Our reference: EF13/3893, DOC16/170030-02  
Contact: John Goodwin

**SSD 7419 – TARONGA AUSTRALIA HABITAT AND WILDLIFE RETREAT DRAFT EIS**

I am writing to you in reply to your invitation to the EPA to comment on the EIS for the above project.

Drawing Title LEVEL 1-RESTAURANT (RL 67)

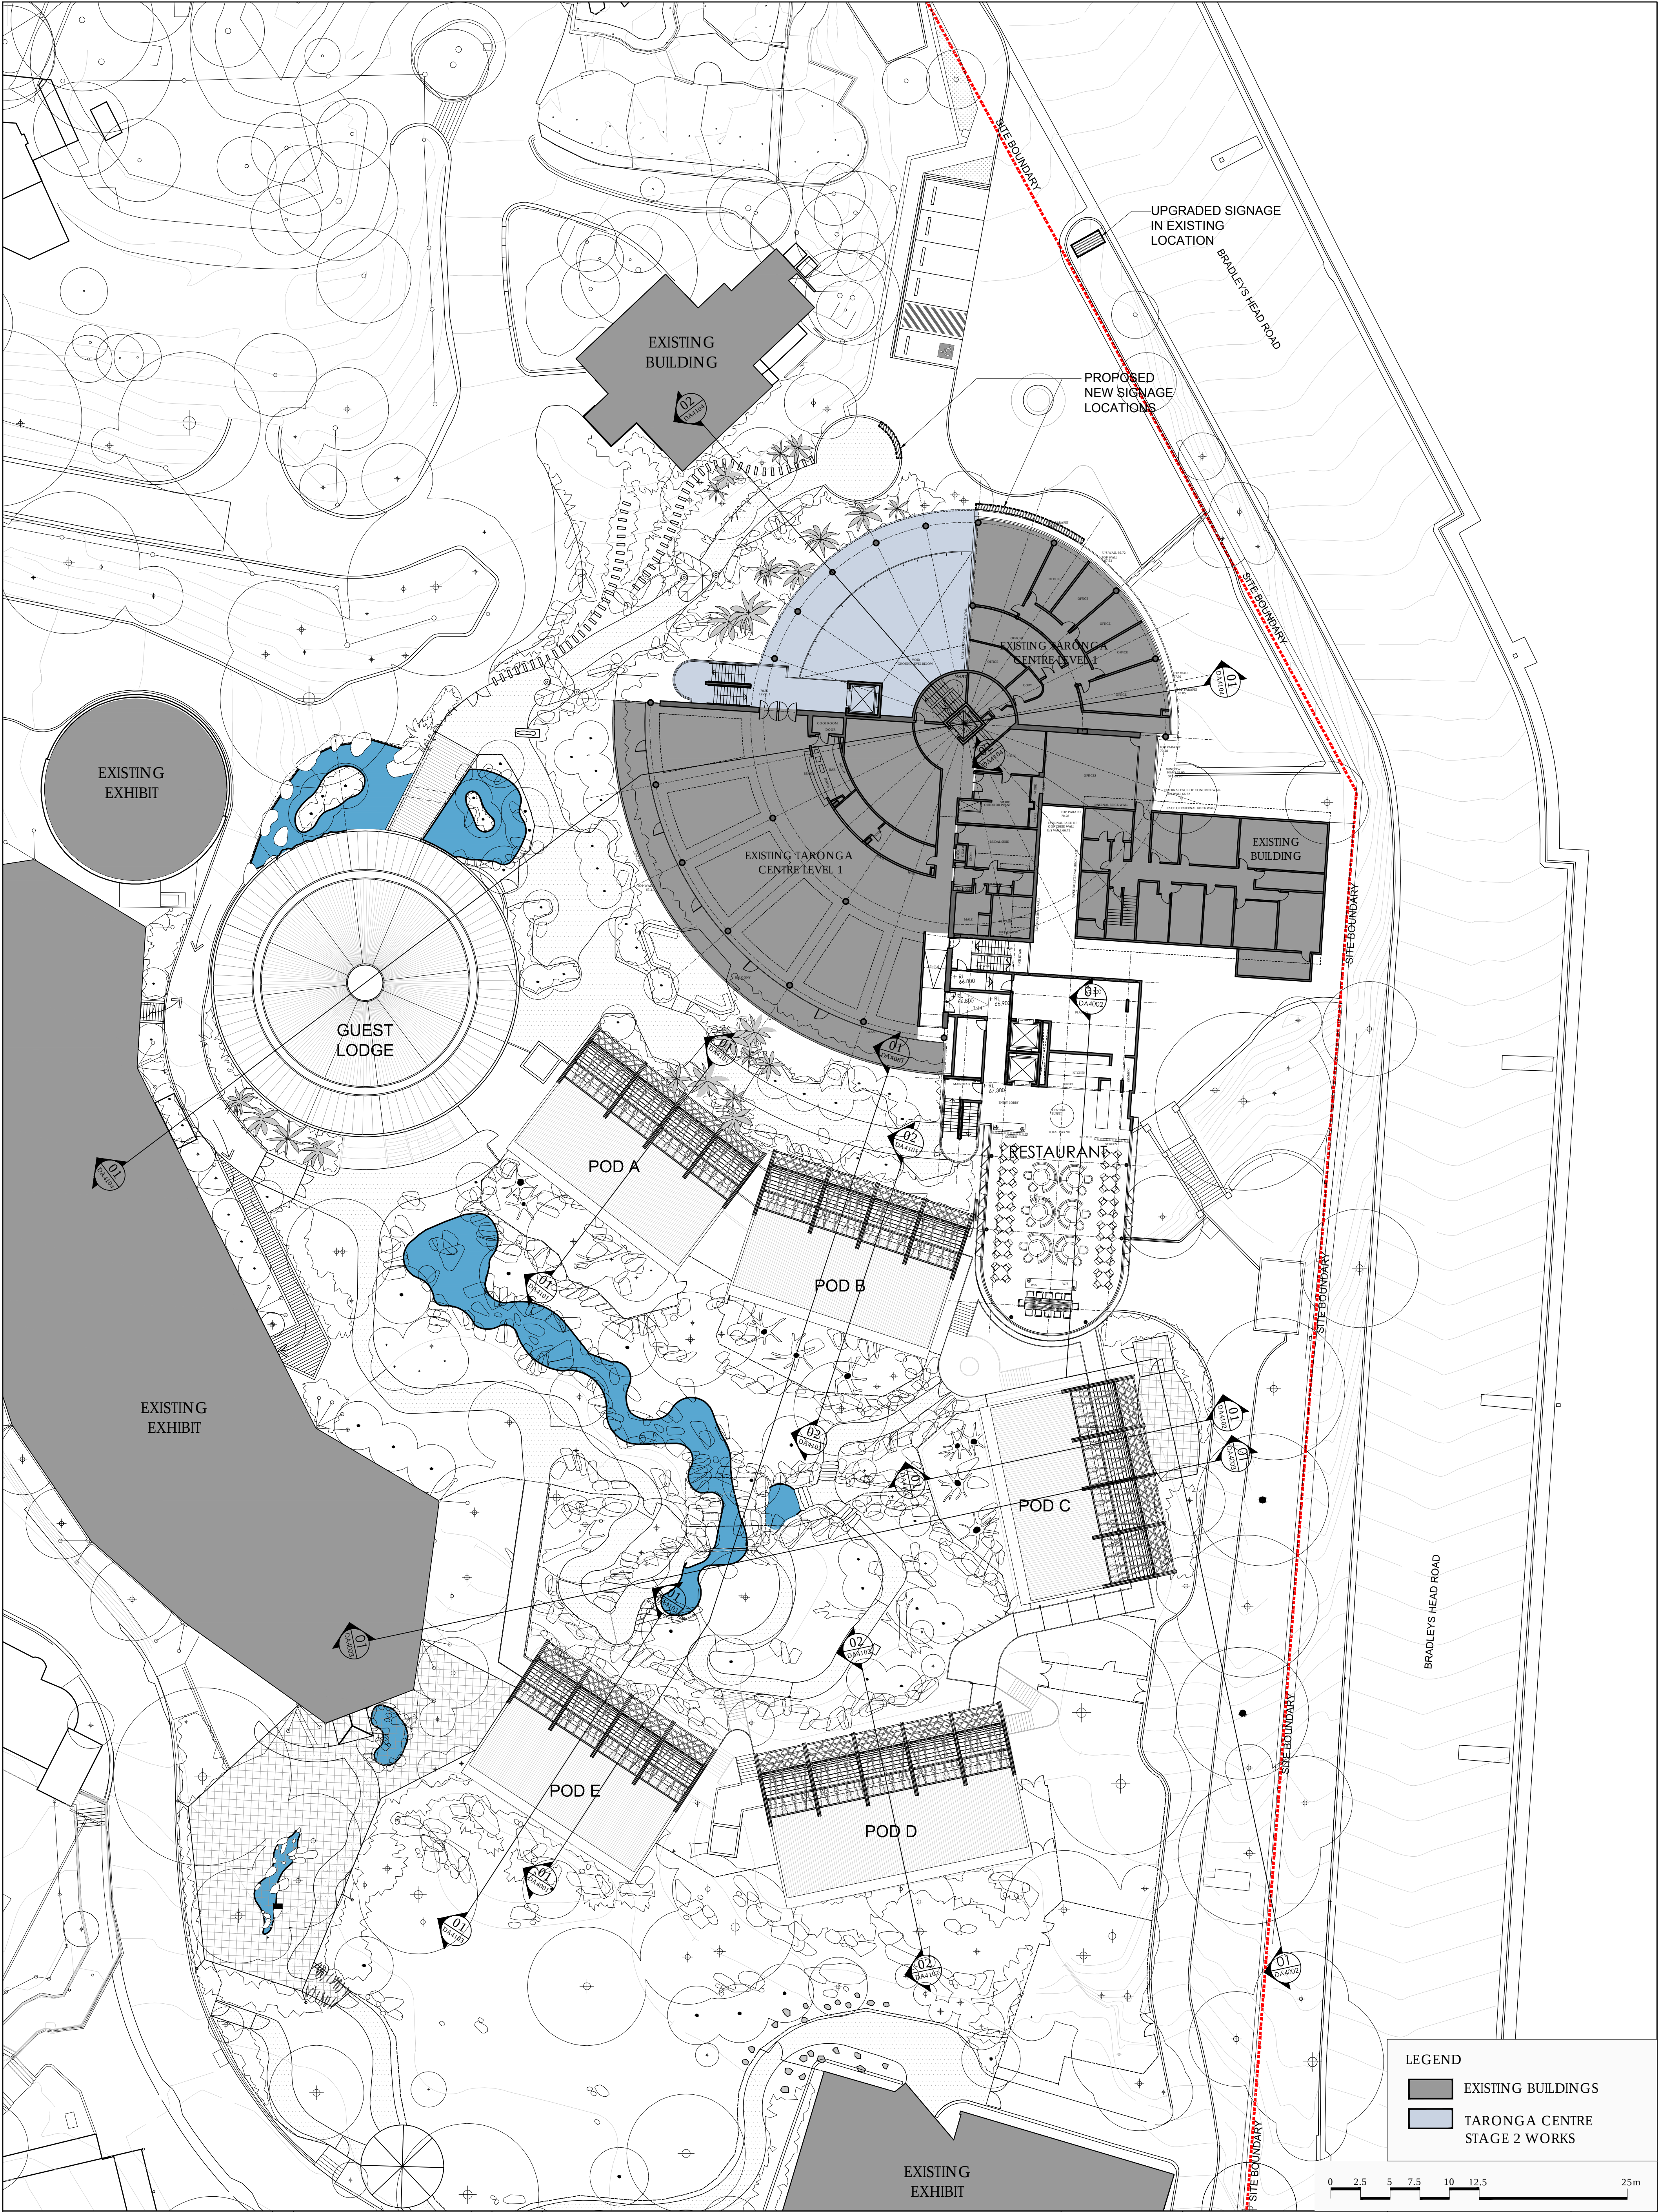
Appendix L section 3.1 proposes that "... the primary sources of noise will be restaurant/lounge activities and any mechanical plant and equipment serving the development." However, The EPA understands that –

- (a) the development will include a dining/function room on the top level (i.e. level 2) with an associated outdoor terrace. (Appendix L indicates that the bar and restaurant are proposed to be operate from 6.00 am to 1.00 am 7 days per week but omits the operating times for the function facilities on level 2),
- (b) EIS section 6.4.1 indicates that parking to serve guest accommodation will be provided in the existing Whiting Beach Road multi-storey carpark immediately opposite residences on the northern side of that road.

The EPA is aware that certain outdoor entertainment activities at the Zoo have been the subject of noise complaints. However, Appendix L does not provide an assessment of typical noise impacts (including sleep disturbance impacts) arising from amplified music and predictable behaviour of function centre and terrace, bar and restaurant patrons.

The proponent should undertake a comprehensive quantitative assessment of noise impacts associated with operation of the new facilities (including evening and night-time car park use) together with design for feasible and reasonable noise impact avoidance and mitigation, including but not limited to:
